Further Highway comments

Do you have any further comments in response to the attached RSA & revised tracking drawings.

Tracking Plan : Option 3
scale 1:500 @ A1

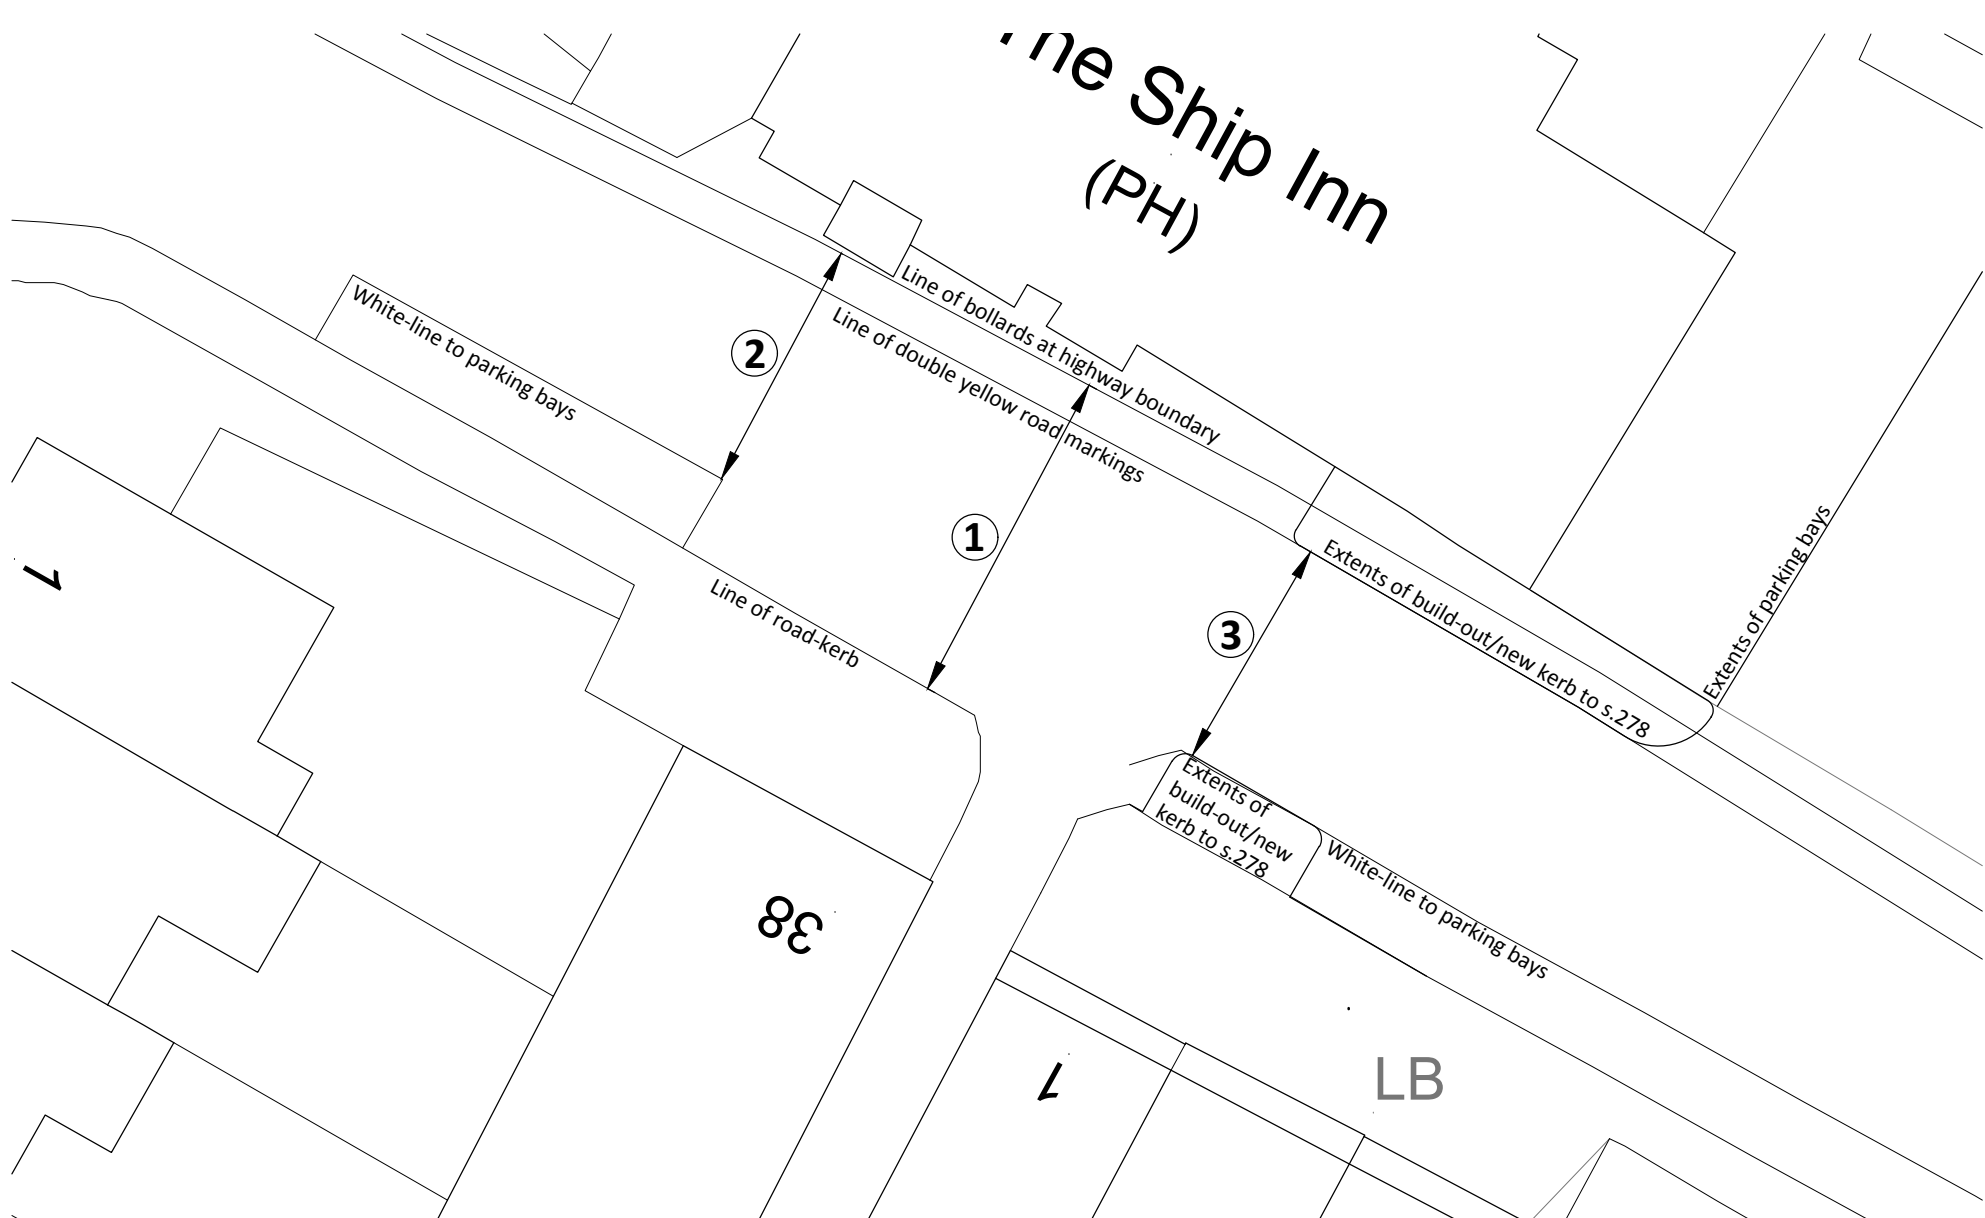
I would also like to highlight that the tracking plans will need to be re-done to be as realistic as possible.

These will need to include the parking bays at the western end of Aldwick Street, adjacent to Goodwood Motors. I notice this is not included in the current diagrams, and neither is the proposed footway with dropped kerb to the north.

Dimensions should also be shown on these diagrams so we can see how wide the carriageway is here as this was highlighted in the RSA.
